Your Ref: 000014143
Our Ref: A/112/12/ 01-11-2012
Please ask for:
Mr P Cleveland

Rear decking and fencing to form outside seating area
Lamb Inn The Square Angmering Littlehampton

A/112/12 Lamb Inn Rear Decking and Fencing to form outside seating area

EXISTING & PROPOSED BLOCK  
THE LAMB, THE SQUARE  
ANGMERING, WEST SUSSEX  
BN16 4EQ  
CLIENT Mr Newbon

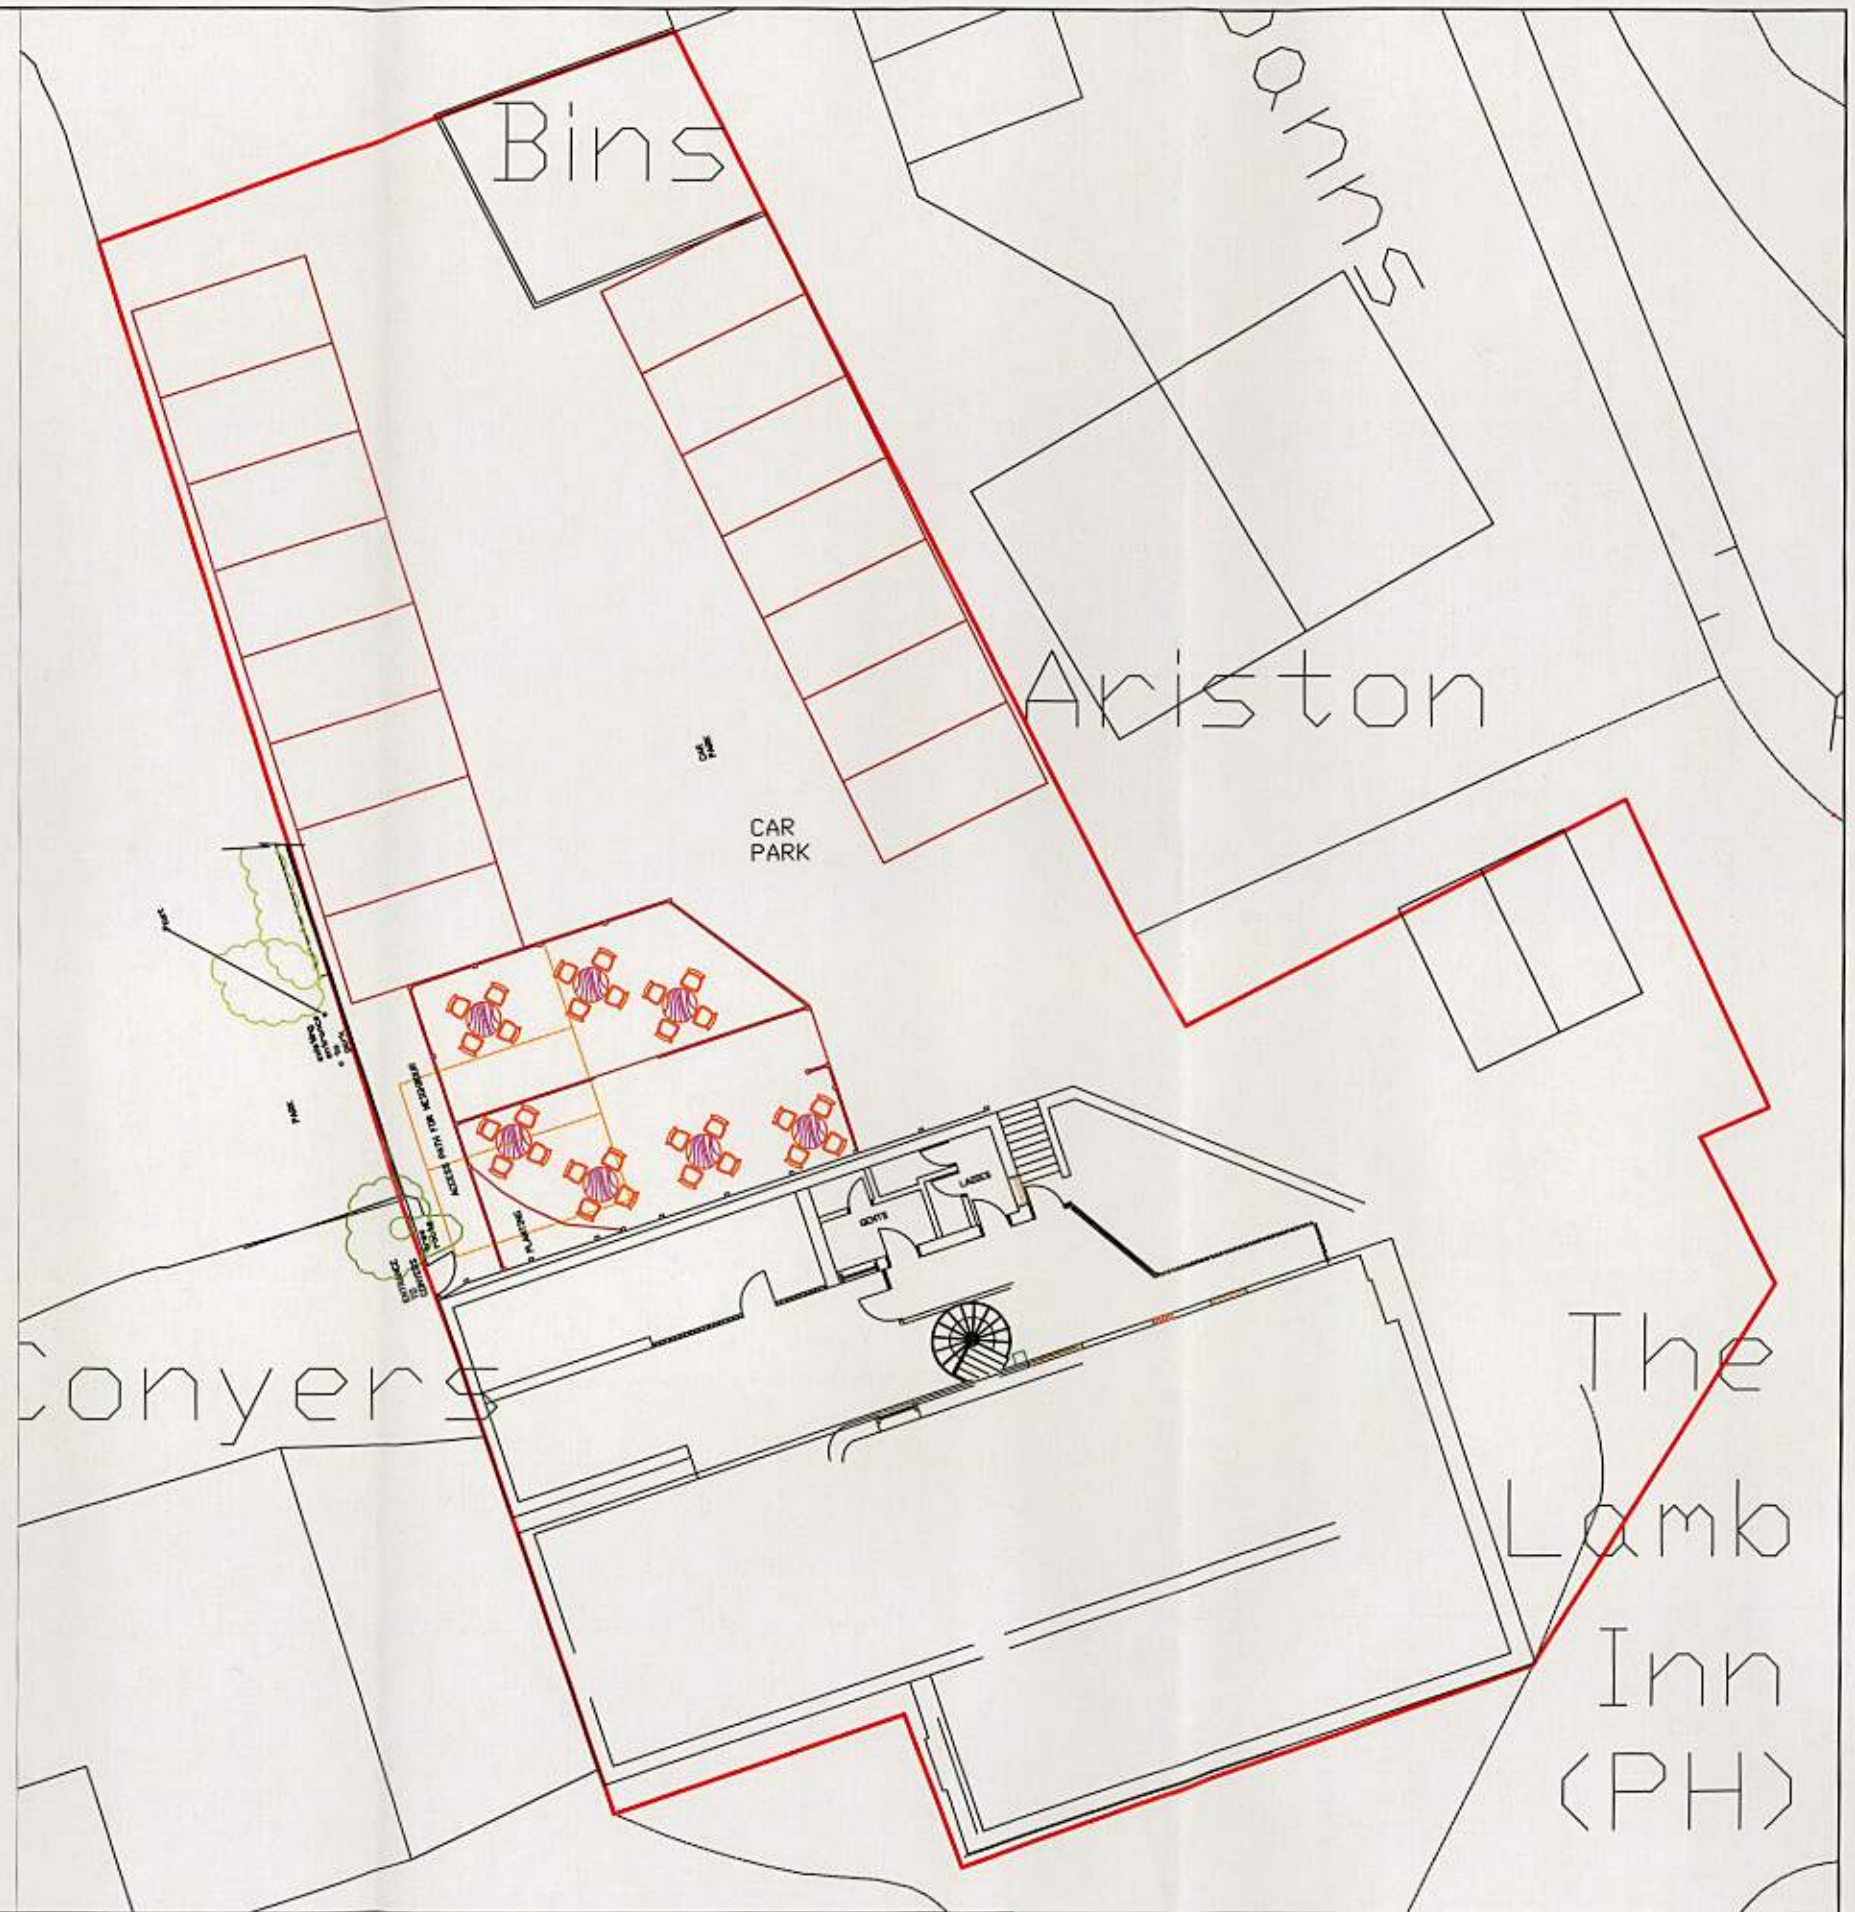
The Applicant refers to the access to the park as being an informal arrangement and I note (with concern) that the Statement (02/11/2012) that was submitted with the application and which referred to the proposed relocation of the existing entrance to the park to slightly west of the proposed decking has been superceded by a Statement (30/11/2012) that makes no mention of such a relocation, and by inference intends to deny access in the future. In fact, the plans indicate that fence screening would block the existing access.
